Planning Application Ref: 2024/90273

Description: Erection of Two Semi-Detached Dwellings

We write to object to the above planning application for the following reasons:

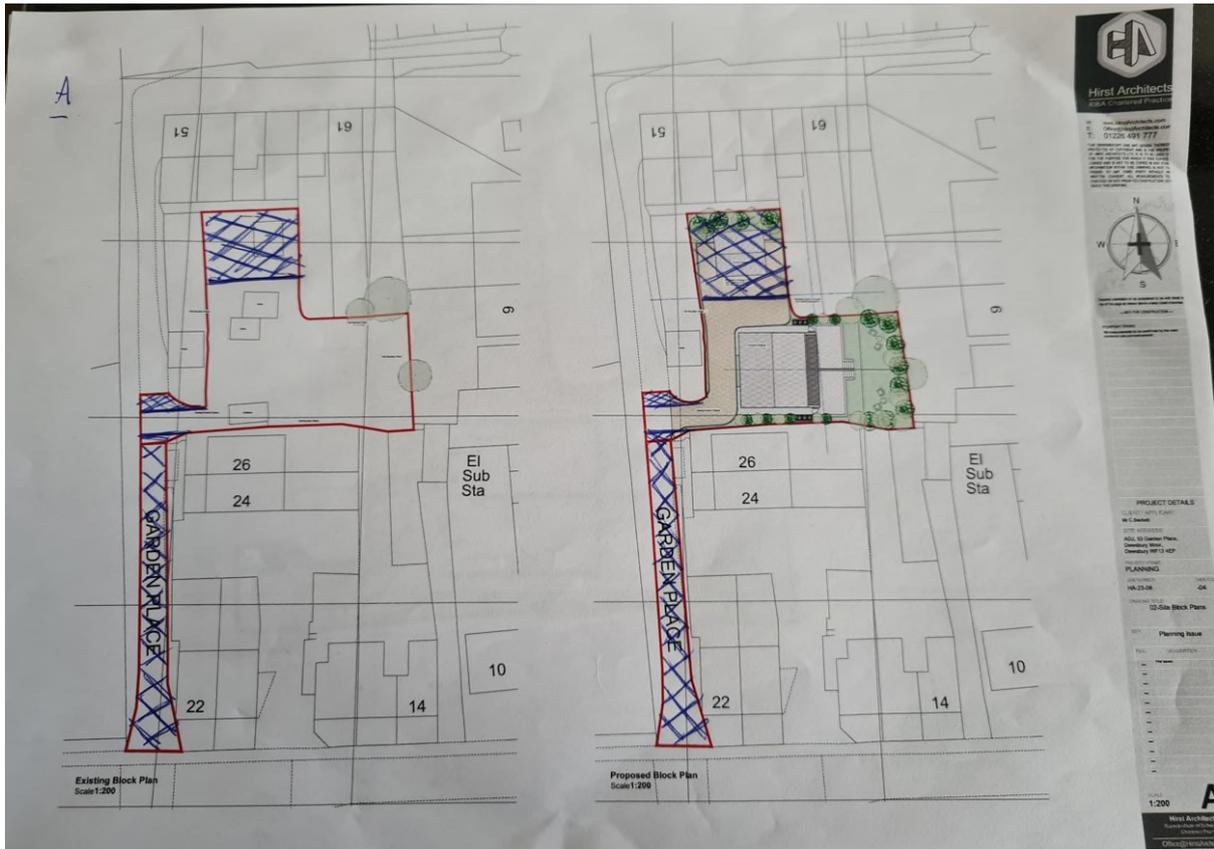
1. The boundary lines in the proposed development plan are incorrect. The garages proposed are on the land owned by 53 Garden Place. We feel this is a misrepresentation of proposed development plans and their boundaries. True boundary lines marked – see Diagrams A/B
